Application by Oaklands Farm Solar Limited for an Order Granting Development Consent for Oaklands Farm Solar Park
The Examining Authority's draft first written questions and requests for information
Issued on 18 June 2024

The following table sets out the Examining Authority's (ExA's) draft first set of written questions and requests for information (Draft ExQ1).

Figure 15.1: Agricultural Land Classification results

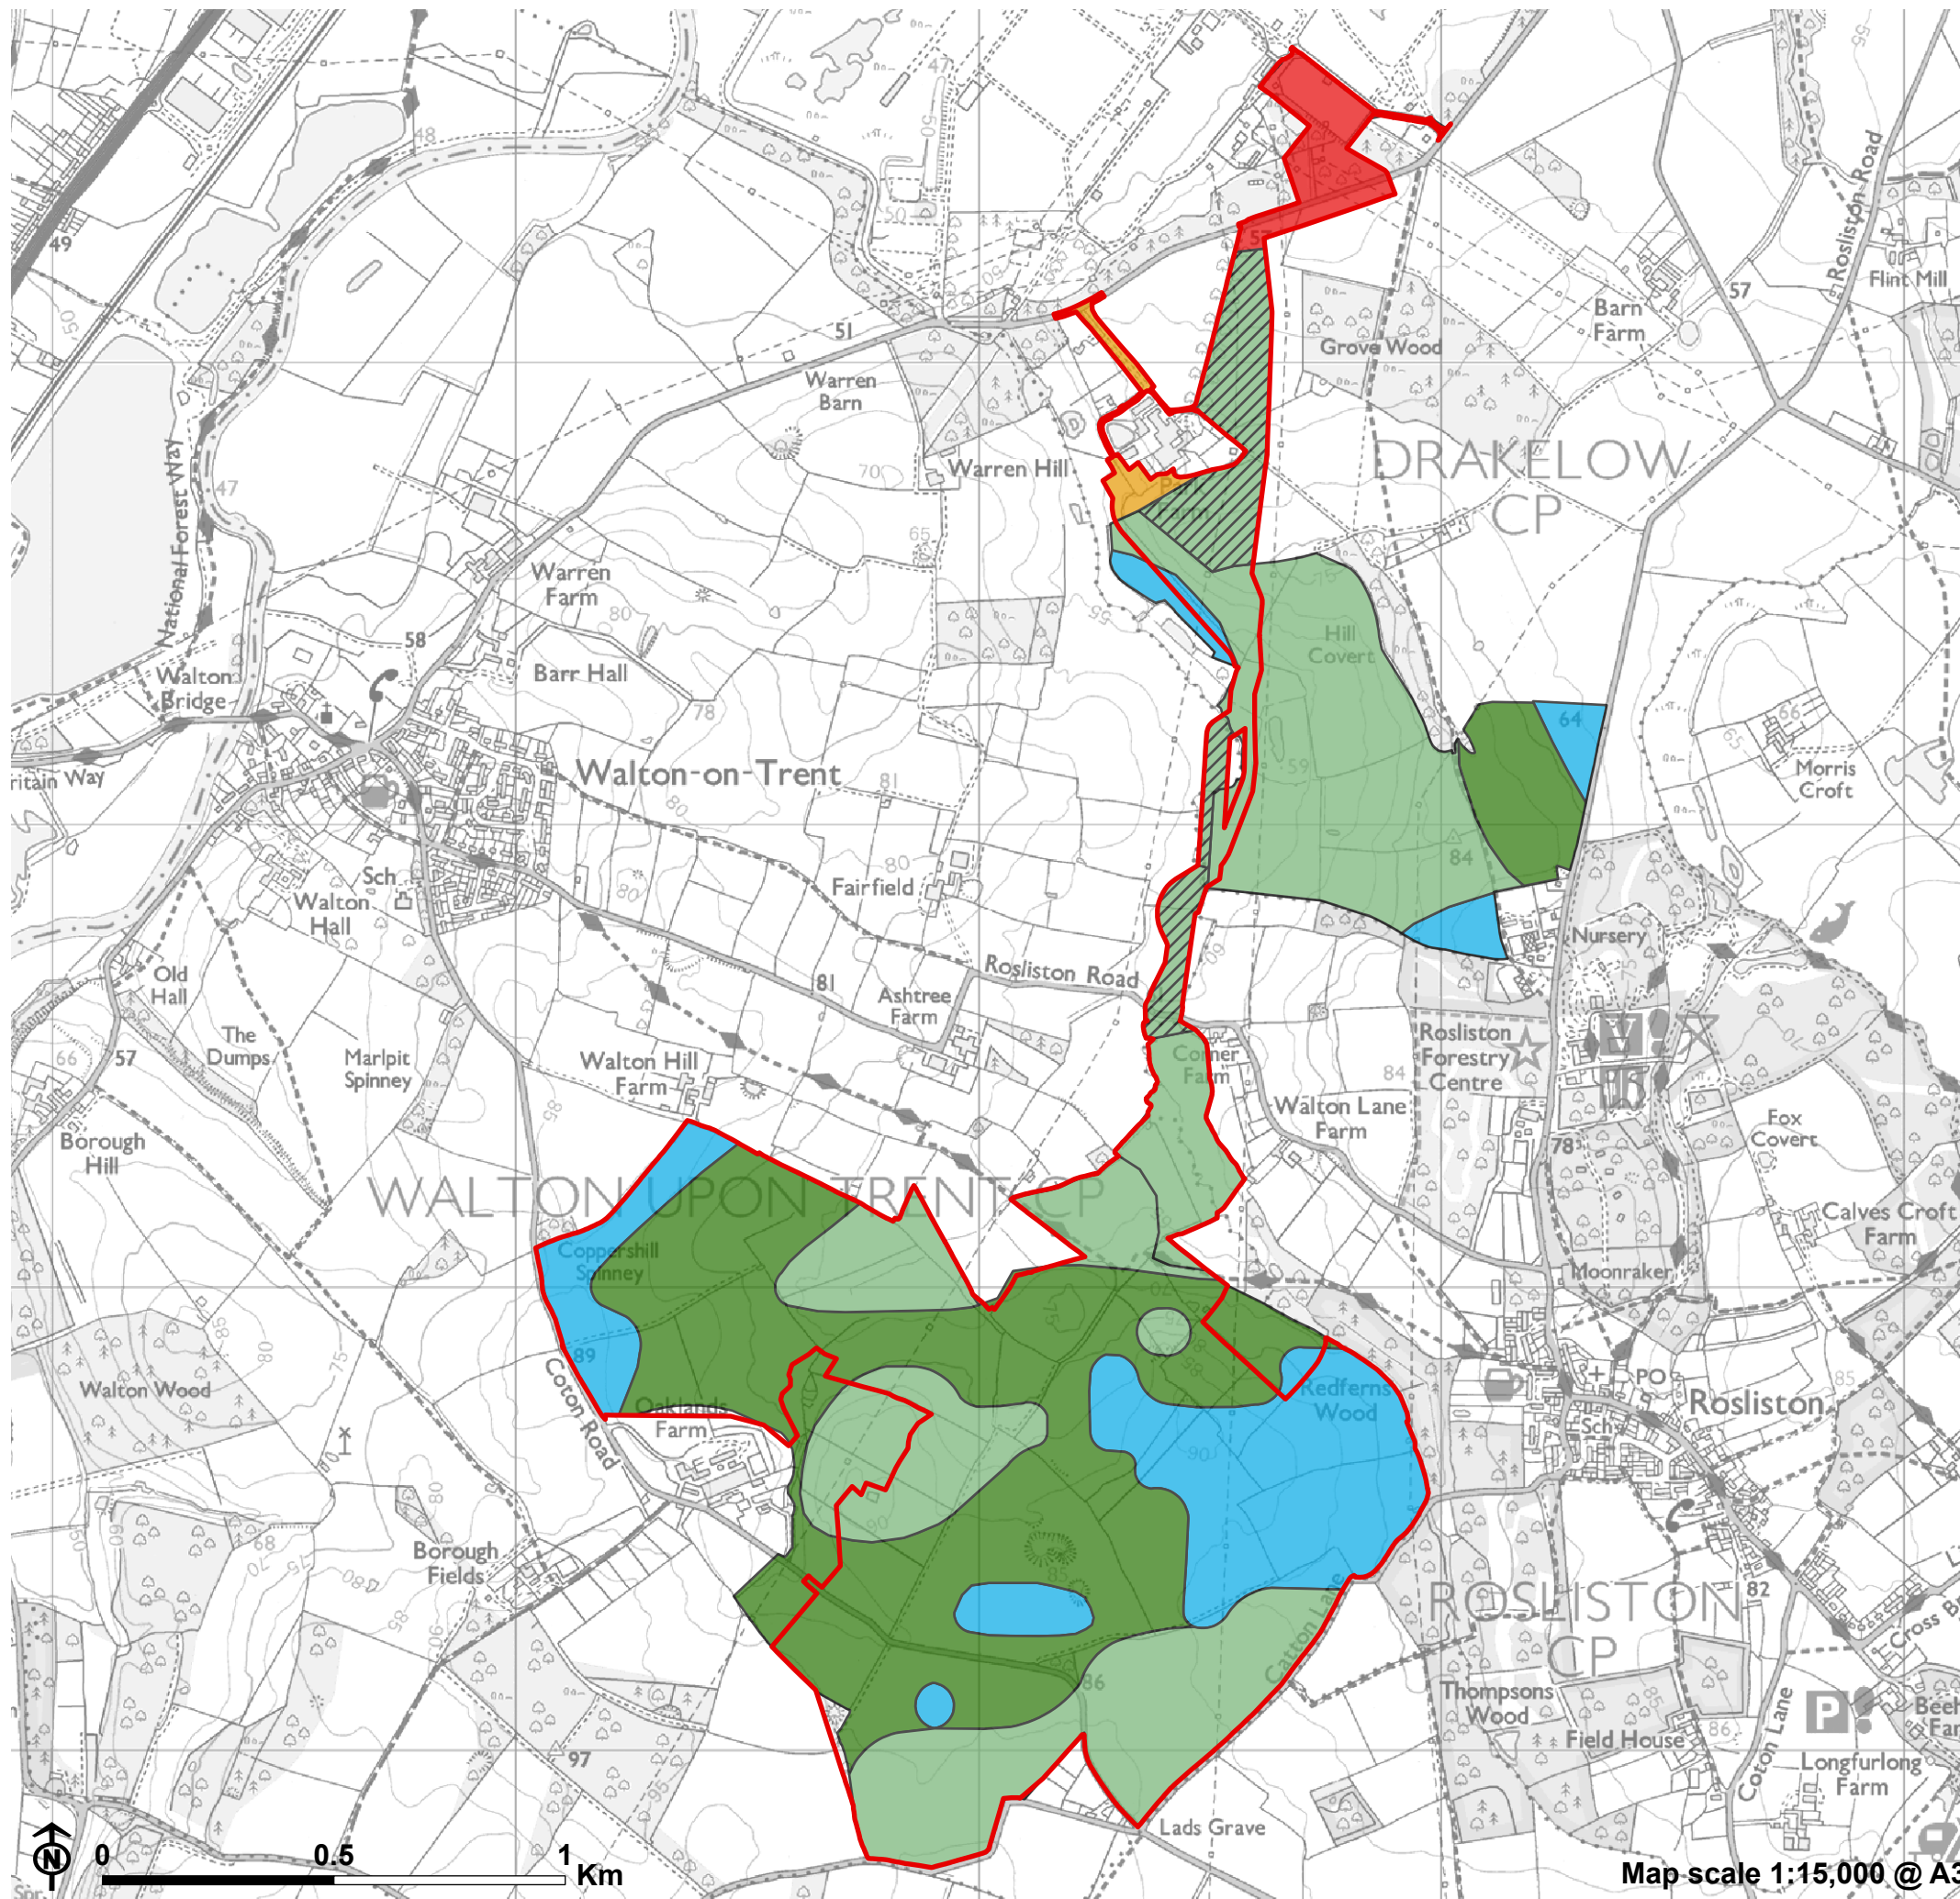
Ref:	Question to:	Question:
6.2	NE SDDC	<p><u>Agricultural Land Classification (ALC)</u></p> <p>Paragraph 2010.33 of NPS EN-3 states that the ALC is the only approved system for grading agricultural quality in England and, if necessary, field surveys should be used to establish the ALC grades in accordance with grading criteria and identify the soil types to inform soil management at the construction, operation, and decommissioning phases in line with the DEFRA Construction Code.</p> <ul style="list-style-type: none"> a) Are NE and SDDC content with the Applicant's ALC and surveys [APP-168, APP-169, APP-170, APP-171]? b) Is Subgrade 3b a robust worst case assumption for the areas that were not surveyed [APP-168]? c) Should surveys be required of areas that were not surveyed to rule out that they could be BMV agricultural land?
